**Date:** 02/04/2025

**Re:** **Framing Issue**  
Location: Lot 573 Creekside Oaks North (335 Greenbay St. (Lillington, NC))  
JDS Project No.: RDU2501120  
Date of Inspection: 02/04/2025

TITLE
UPPER FLOOR PLAN

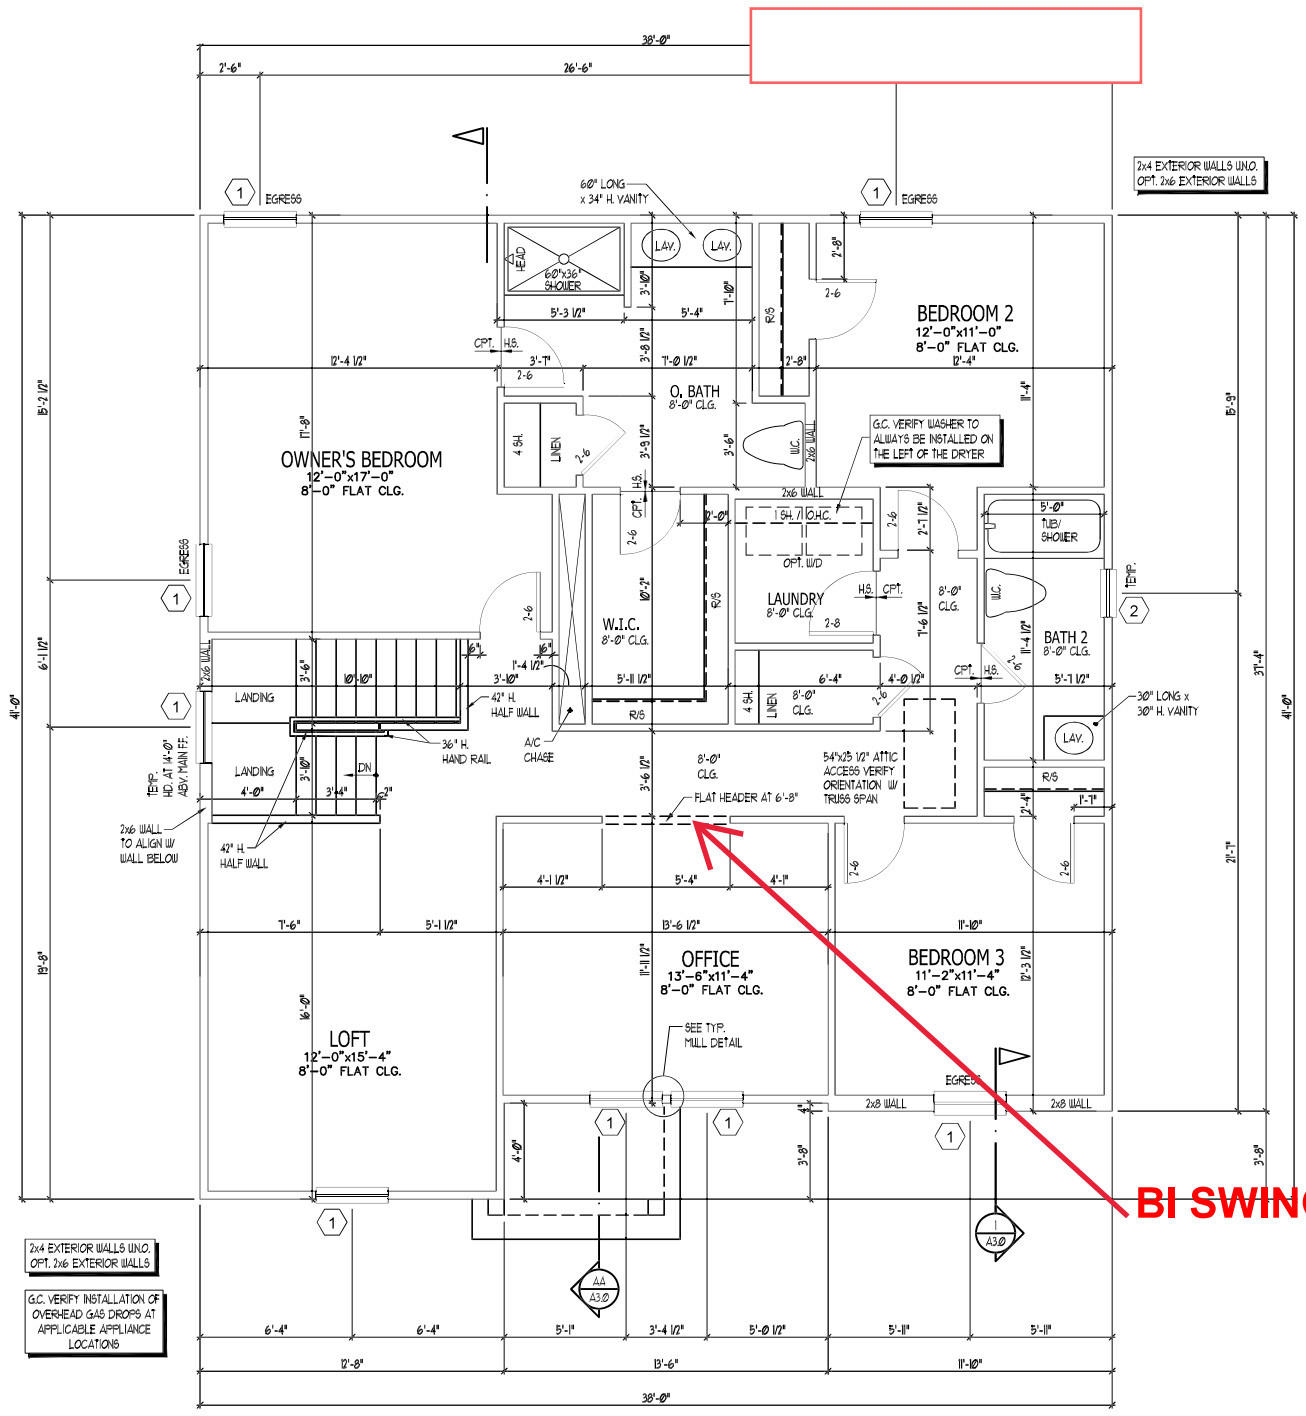
The client requested an evaluation of a framing issue at the front wall of the 2<sup>nd</sup> floor loft area, the plans provided specify a 2x8 framed wall at the location. the framer installed a (2) 2x4 stud wall at the location. The stacked studs are attached with blocks with (2) nails in each stud.

Based on our observations and review, the wall is adequate as installed, no repairs are required.
